Tuck O'Brien
City Planning Director, Planning Division

Project Name: Thames Street Ext.
Address: o Thames Street
Applicant: City of Portland
Planner: Matthew Grooms

Project ID: PL-000226-2018

STORMTREE BASE SERIES
N.T.S.

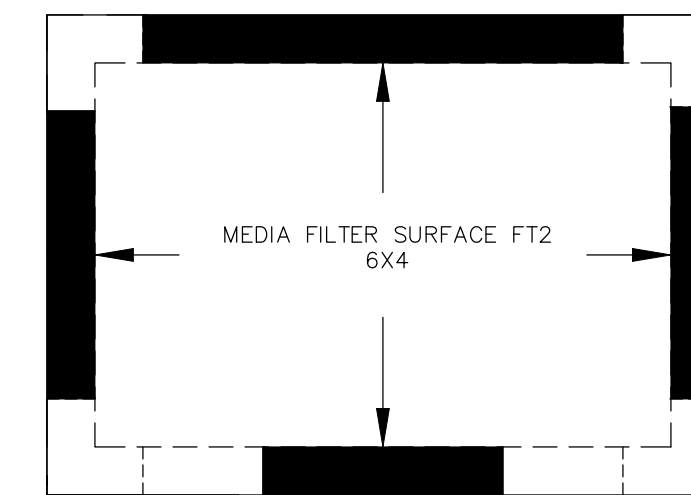
*DETAIL? Rased or flush?
(4'x7' man?)*

BITUMINOUS TRAIL
N.T.S.

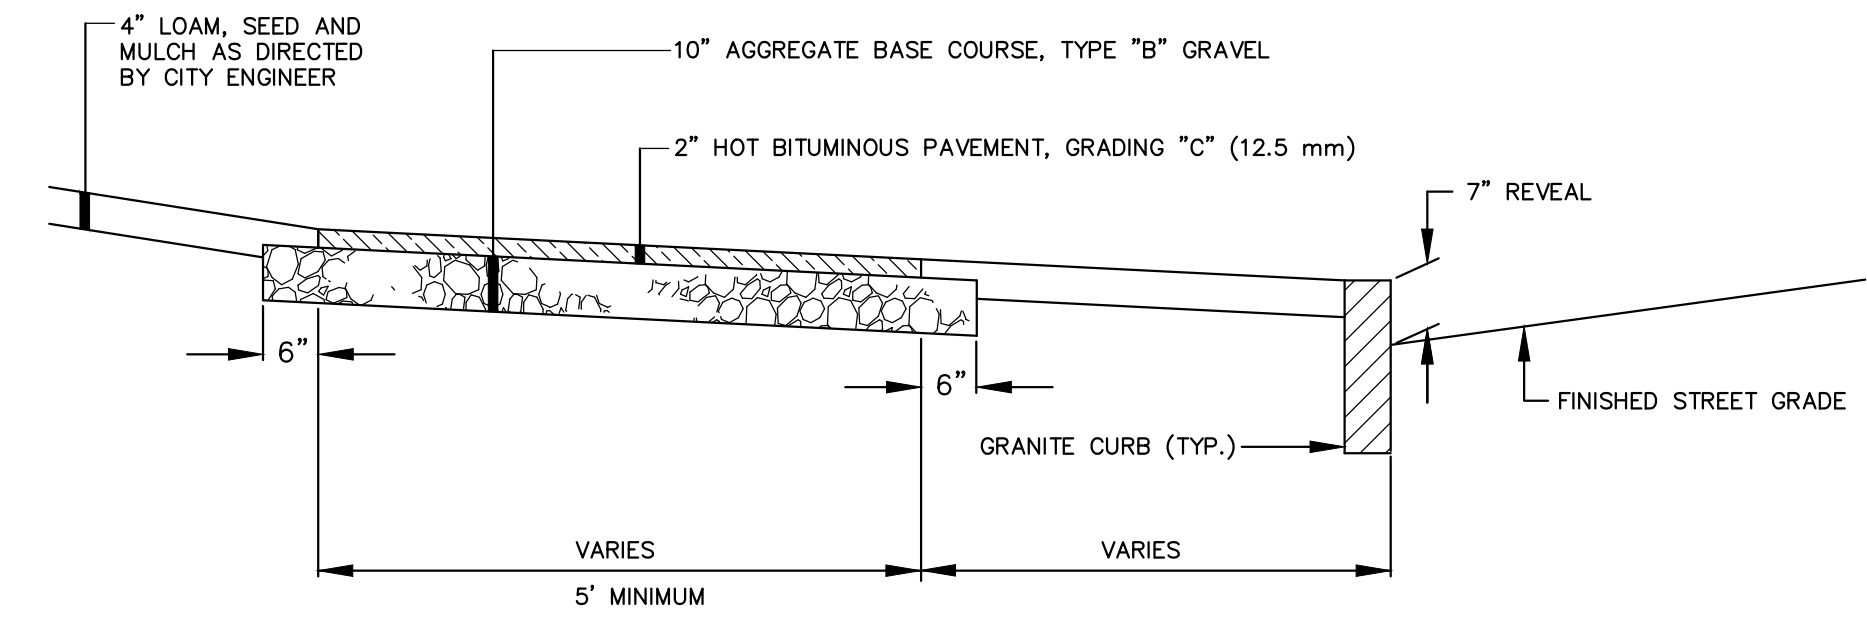
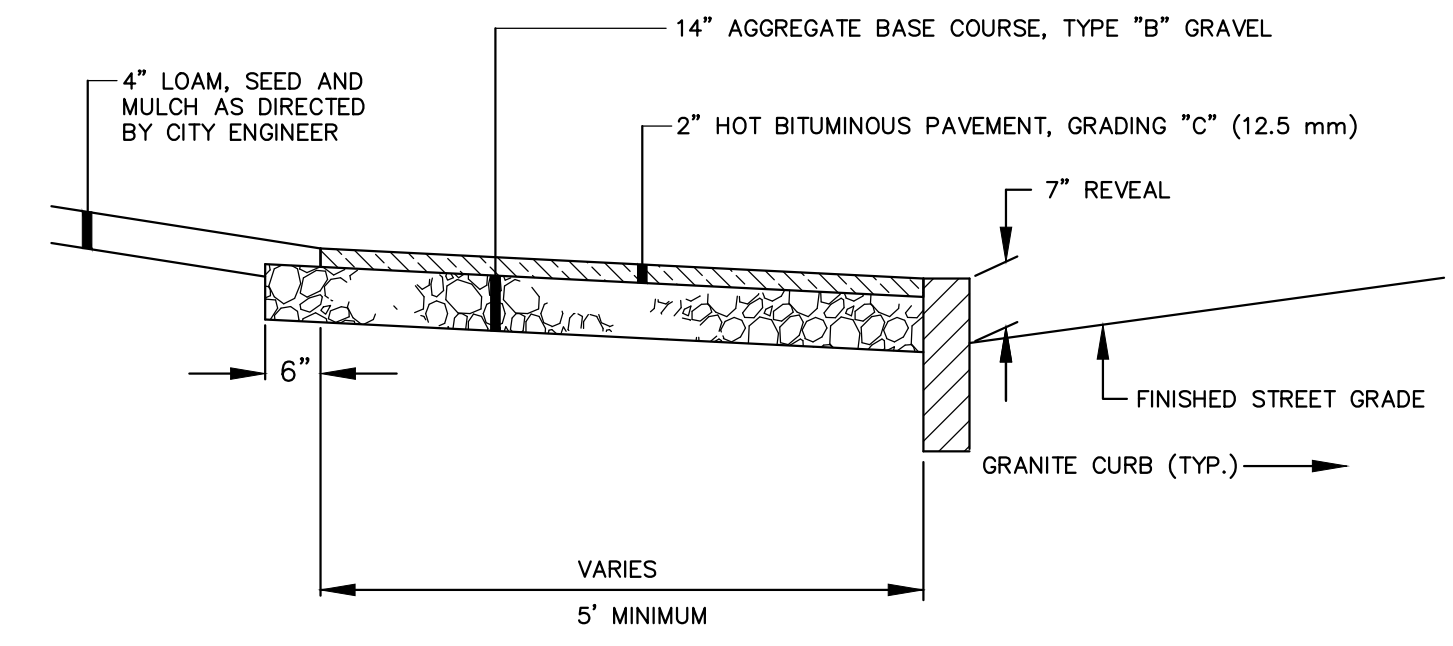
1. The applicant shall submit a revised detail sheet as requested by the City's Transportation Program Manager on October 19, 2018 (see attachment 2) which calls for 2% cross-slope for the trail and sidewalk, and revised detectable warning panel detail.
2. The applicant shall provide an updated site plan with the following information, to demonstrate compliance with the shoreland zone requirements:
 - a. Highest annual tide line and the 75' setback for the Shoreland Zone and Flood Plain
 - b. Zone line between the EWPZ and the B6 Zone
 - c. The flood zone line for A2 flood zone
3. The applicant shall submit a completed Flood Hazard Development Permit and a Flood Hazard Development Permit for Minor Development for the storm water outfall into Portland Harbor.

GRANITE STREET MONUMENT
N.T.S.

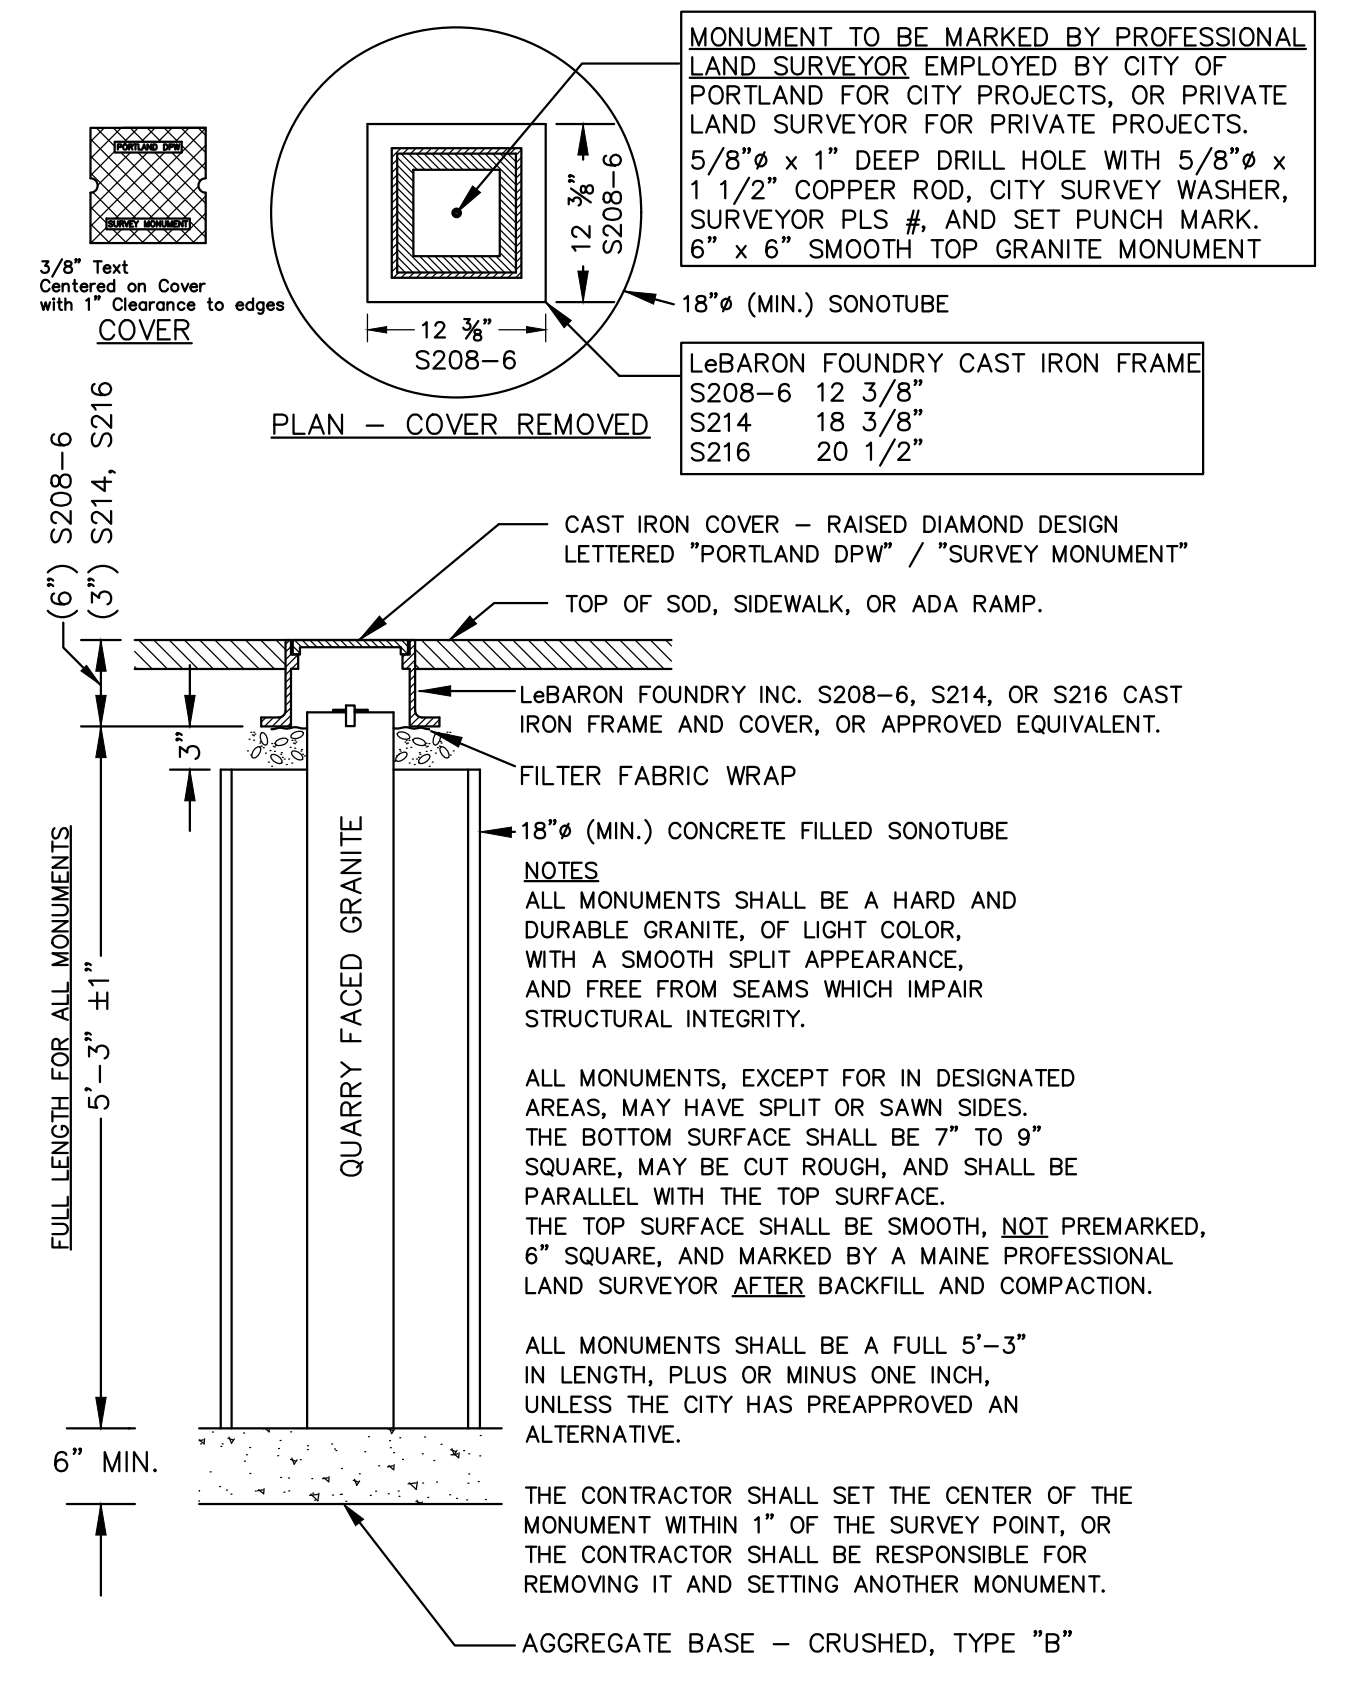
WRONG!!
DETAIL
CONCRETE
cast iron!
